**SITE 53 -
2 FIGTREE DRIVE
SYDNEY OLYMPIC PARK**

ACCESS REVIEW

Morris Goding Accessibility Consulting

16 June 2017

DA-2102	M
---------	---

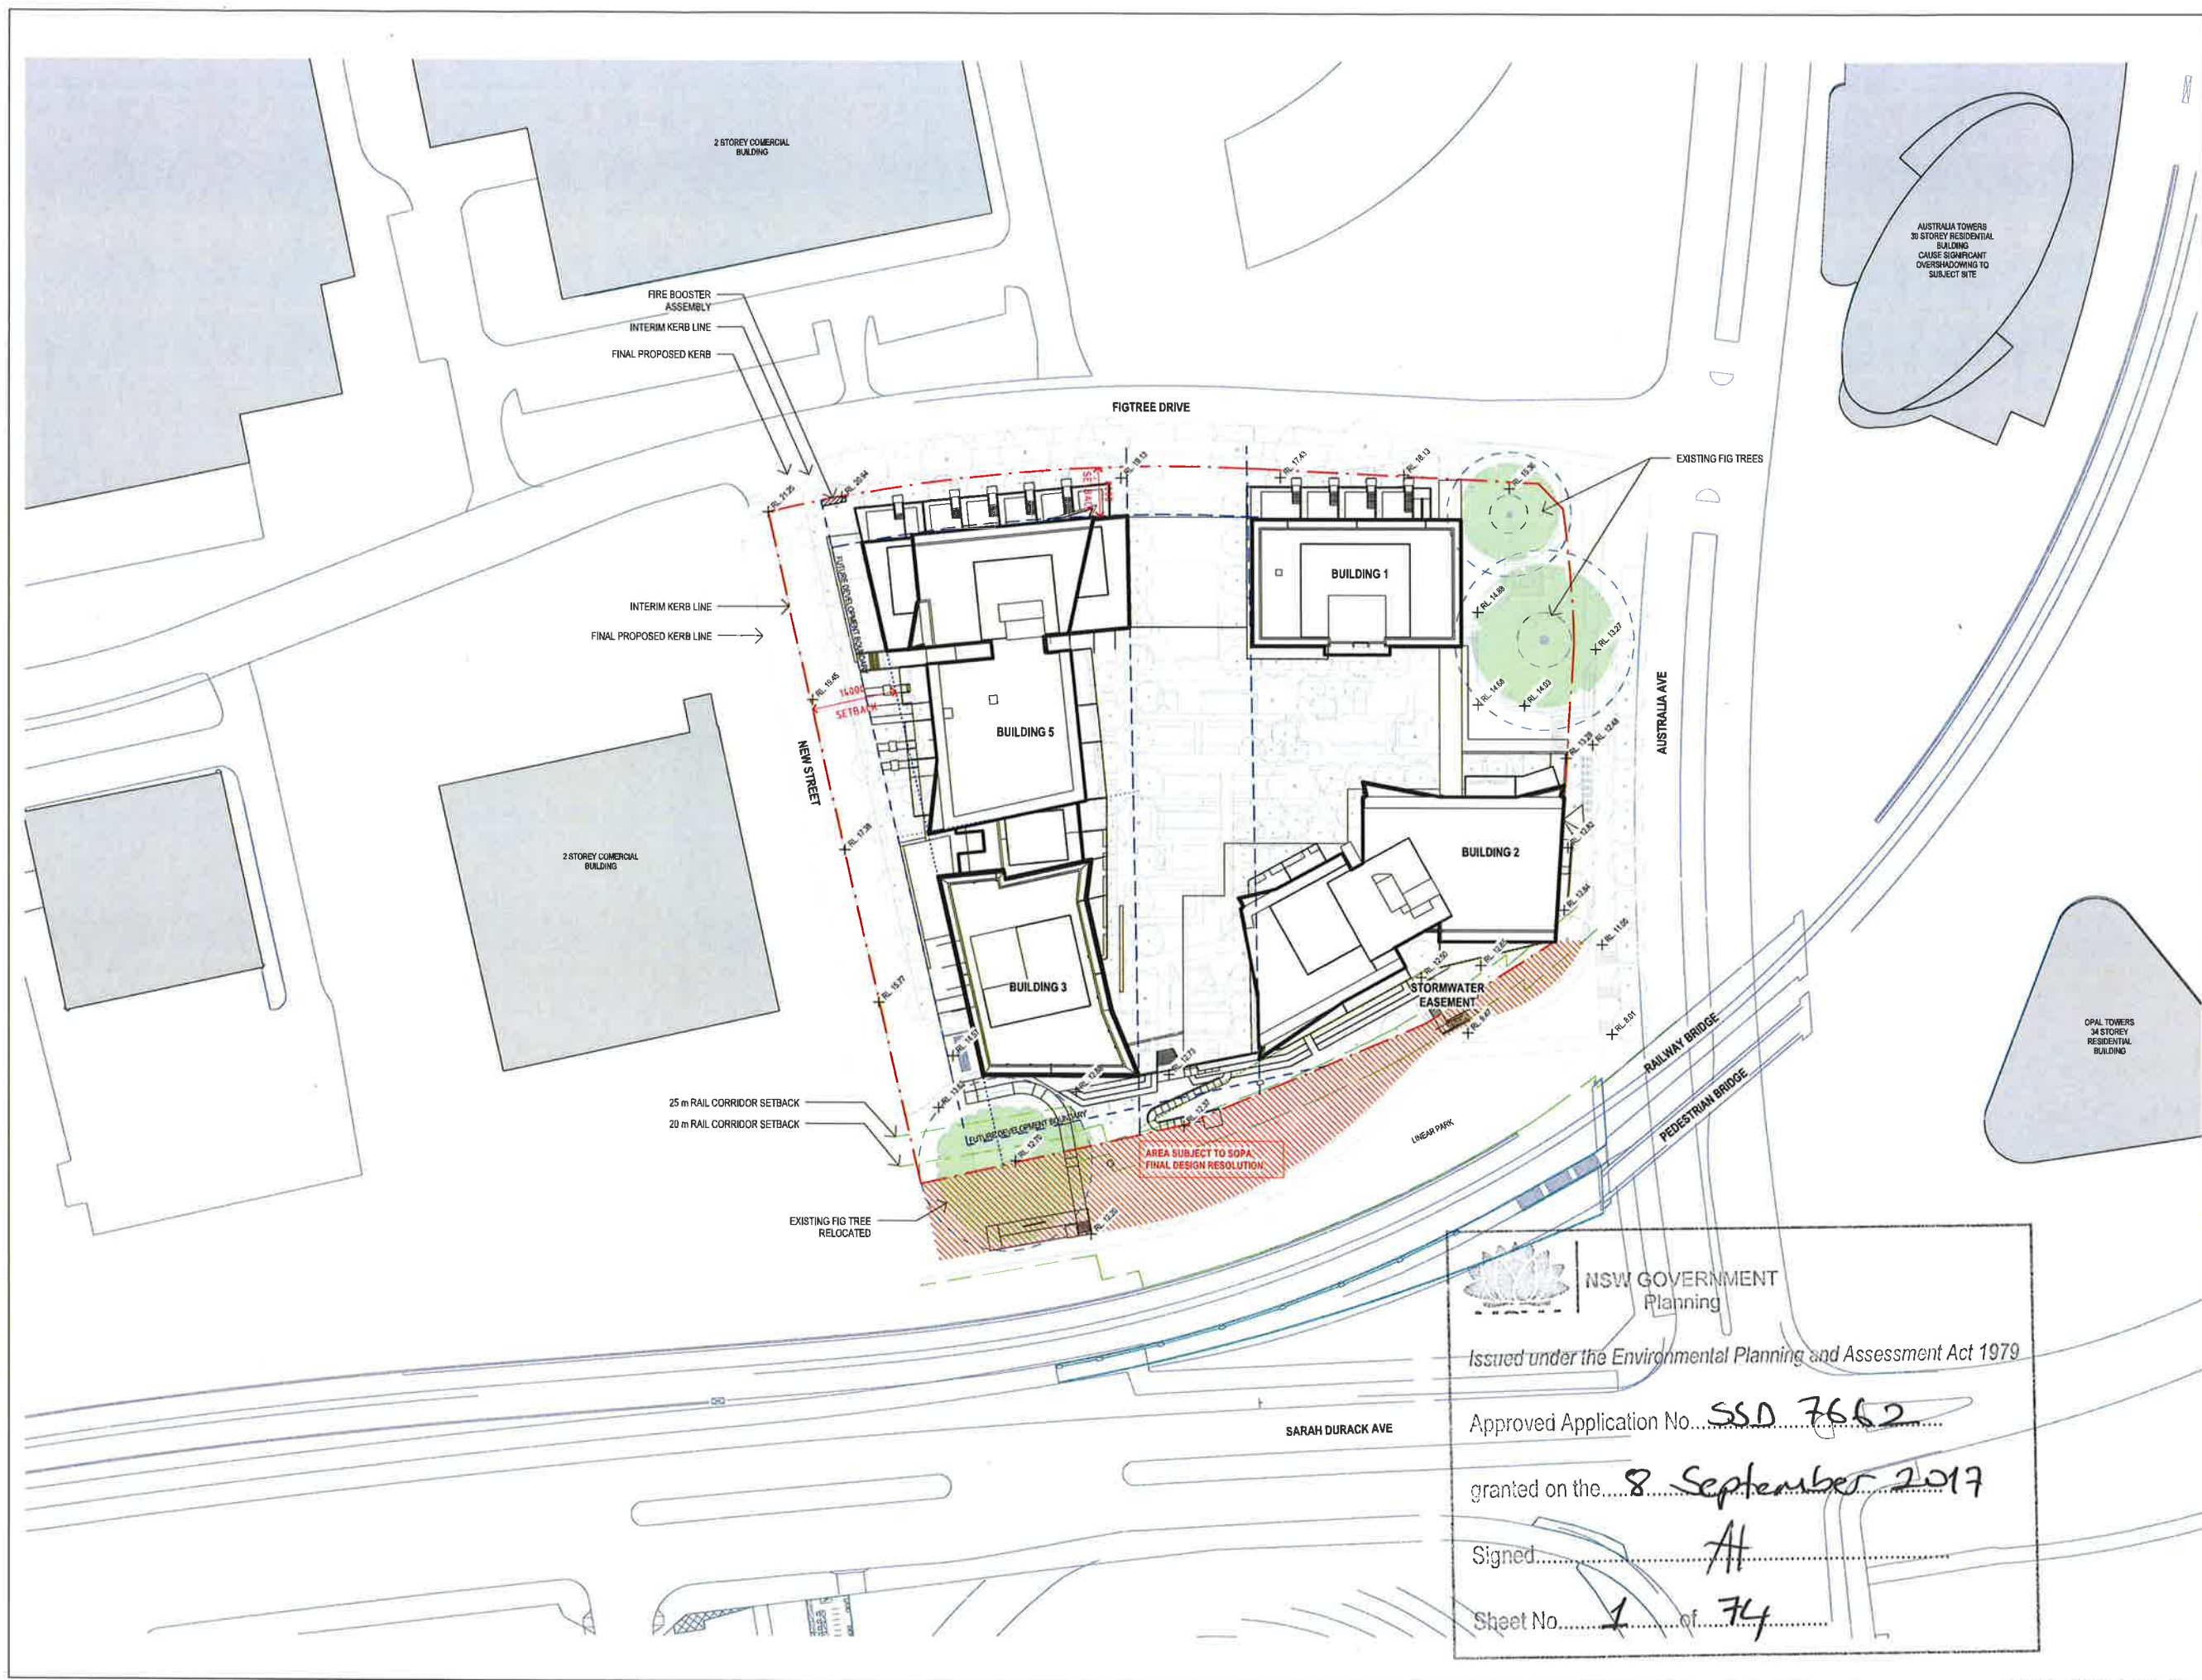
- A performance based solution to meet BCA performance requirements may be required and is supportable for 3 x accessible car bays located across levels B02, B03, B04 where a column is located within shared zone similar to the required bollard location.

- Ensure the recessed lobby space in front of single lift facing north for building 5 that provides at least 1m min. clear length in front of lift doors (basement levels B01, B02, B03, B04) is line-marked in a contrasting colour to identify the waiting/turning area with consideration for overhead signage to advise drivers and improve detectability for pedestrians (advisory).
